**From:** Shane Weir  
**Sent:** 14 November 2022 22:13  
**To:** Ben.Mundy@Oxfordshire.gov.uk  
**Subject:** 22/03049/OUT - Visibility Splay information for Objection  
**Attachments:** Cross-section through vehicular approach to new access.pdf

I wondered if the attached information would be helpful to assist you further with the application 22/03049/OUT at the edge of Kirtlington.

SCALE: 1:500	DATE: 02.09.22	DRAWN: TW	CHECKED: DF	APPROVED: DF
JOB NO: 2207-015	DRAWING NO: VS01	REVISION: A

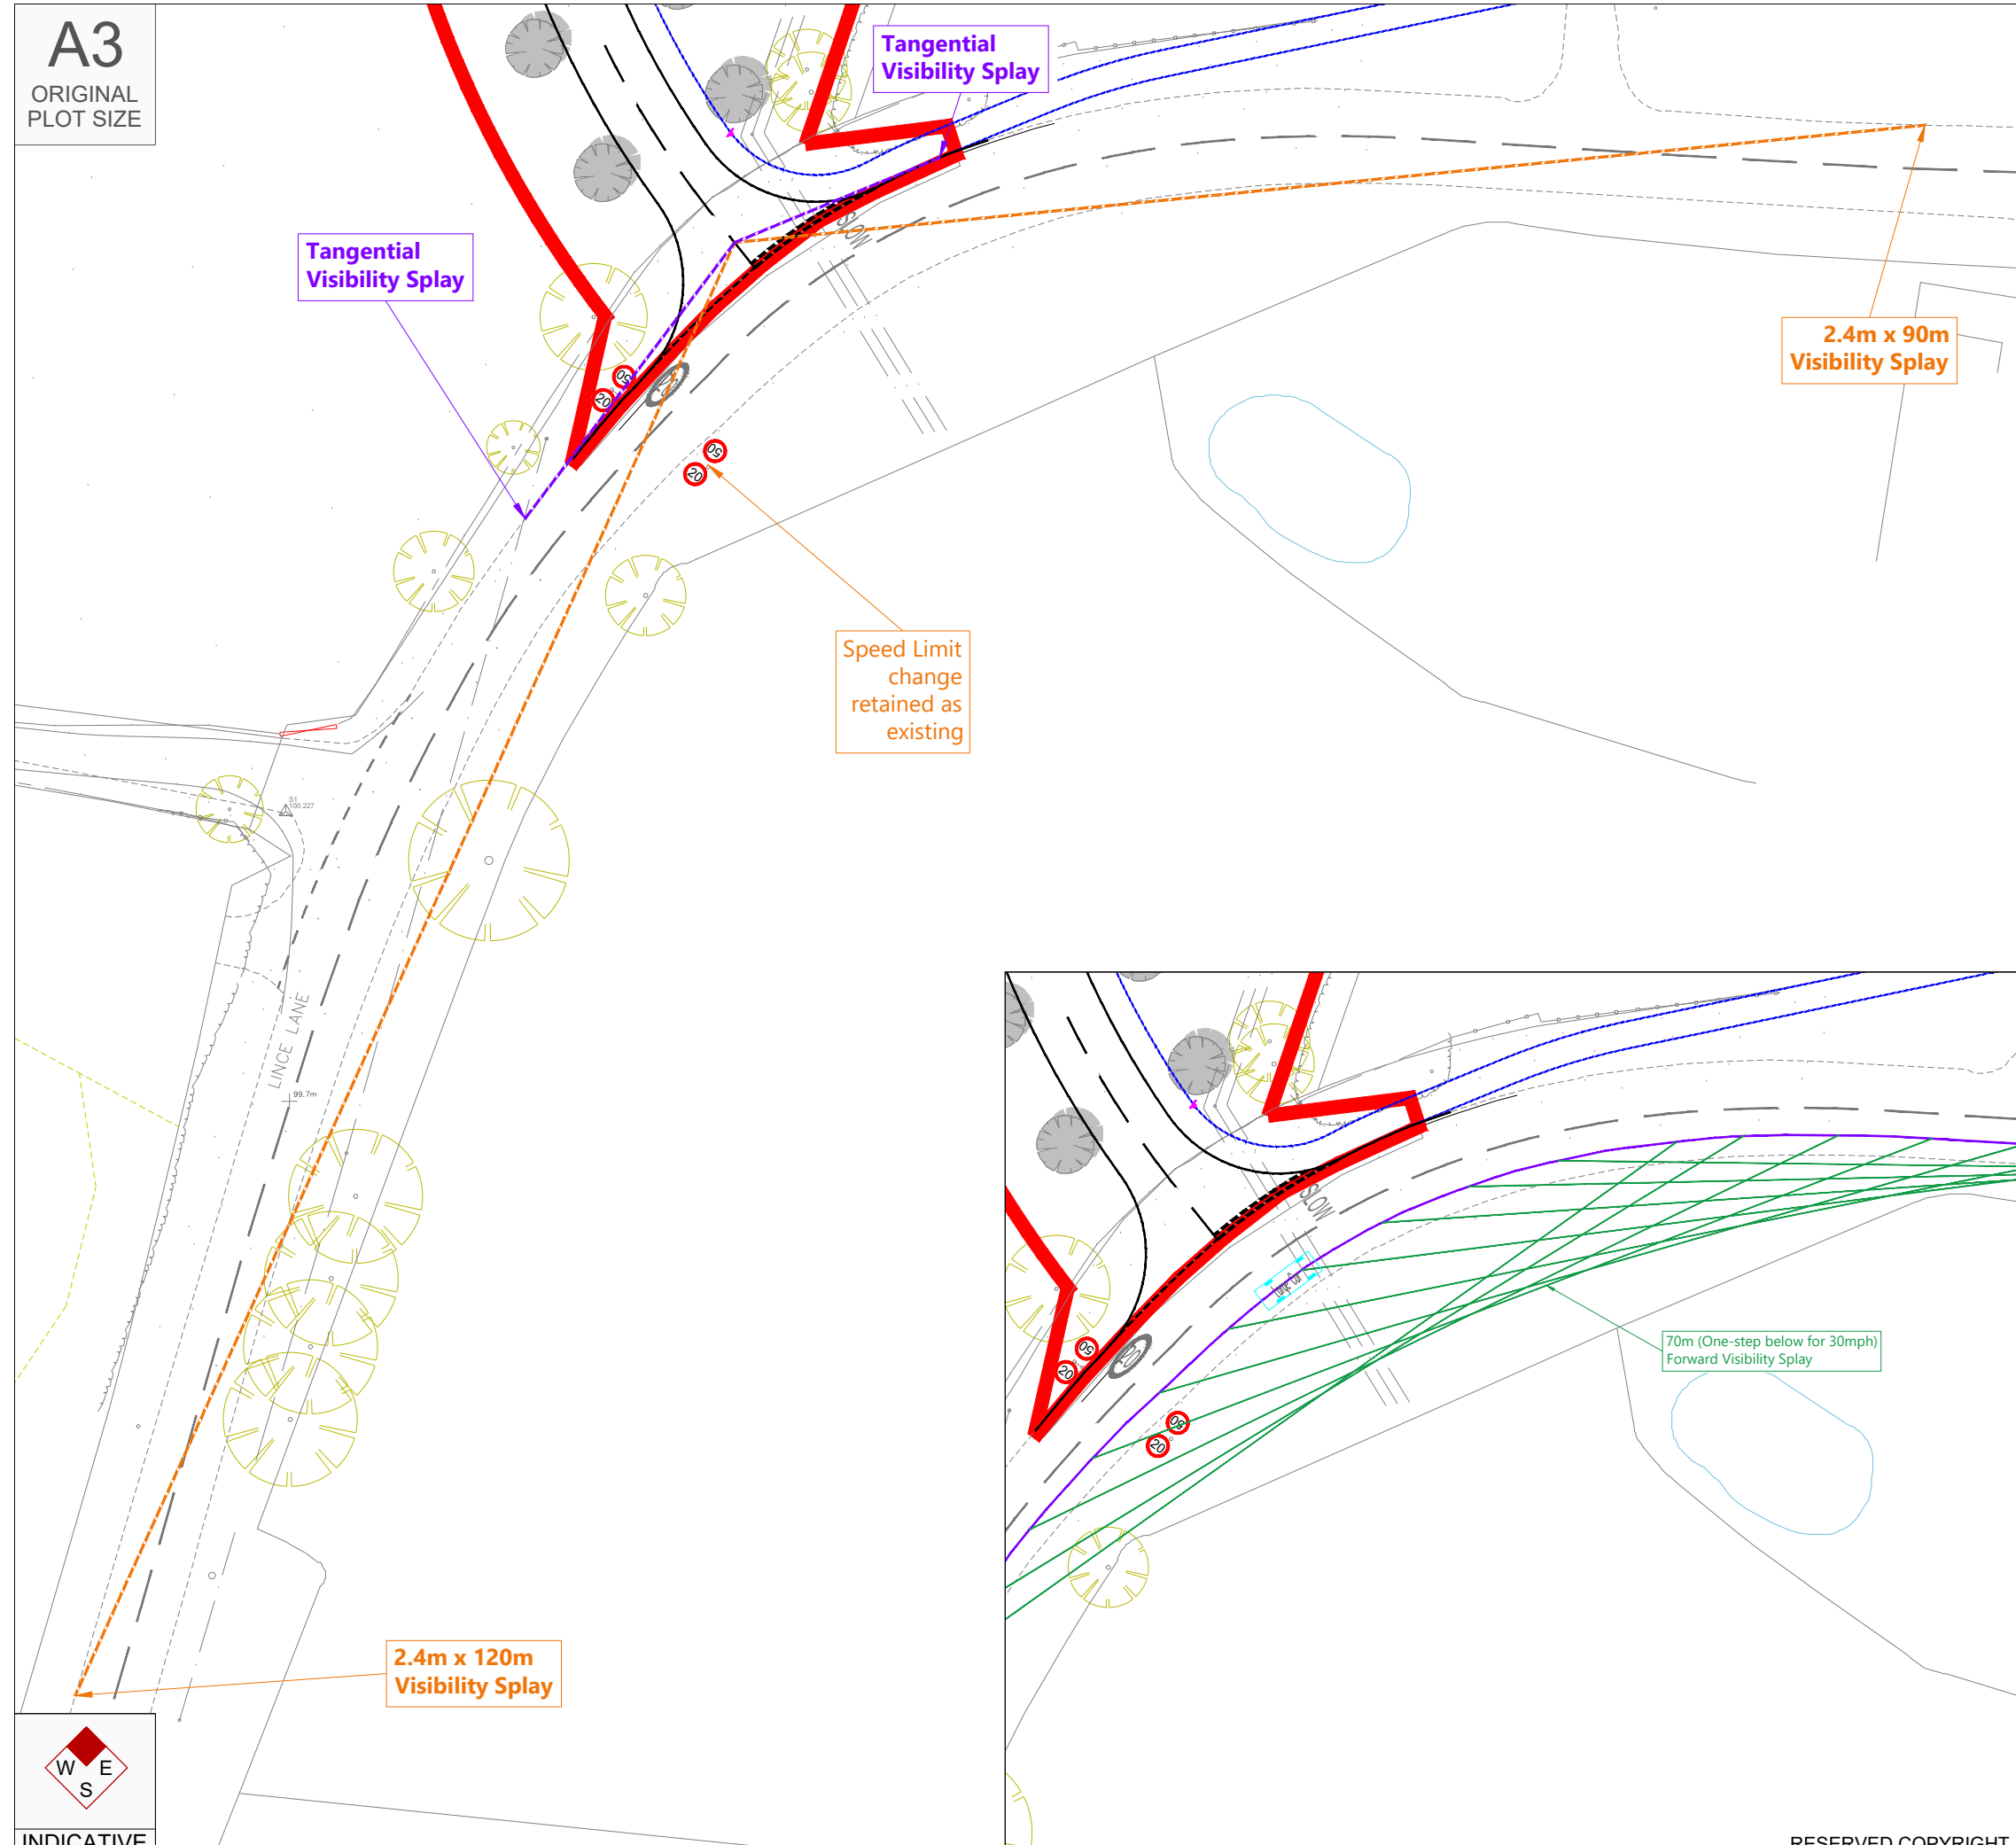
I have taken the liberty to draw up a section through the existing approach road to the village to demonstrate the loss of visibility of on-coming vehicles from the new proposed access. (See attached drawing). I have read through the Country Highways standards and I have concluded that 160m is the visibility splay required for 50Mph speed limit, whereas I note the submitted transport statement states 130m.

The visibility splay that is shown in the Transport Statement is only shown on a plan, and makes no allowance for the topography / levels. I have used the surveyed existing spot levels shown on the drawings within the Transport Statement to inform the longitudinal cross-section through the road (attached), so it has been drawn accurately to 'actual' levels.

As you can see on the drawing, a vehicle pulling out from the new proposed access will ONLY have a maximum of 92metres visibility of vehicles travelling 50mph, which is way under the required distance of 160metres. Further to this, the village does not have any street / road lighting of any kind, so the situation at night or bad weather conditions will be even worse – further reducing visibility of on-coming traffic.
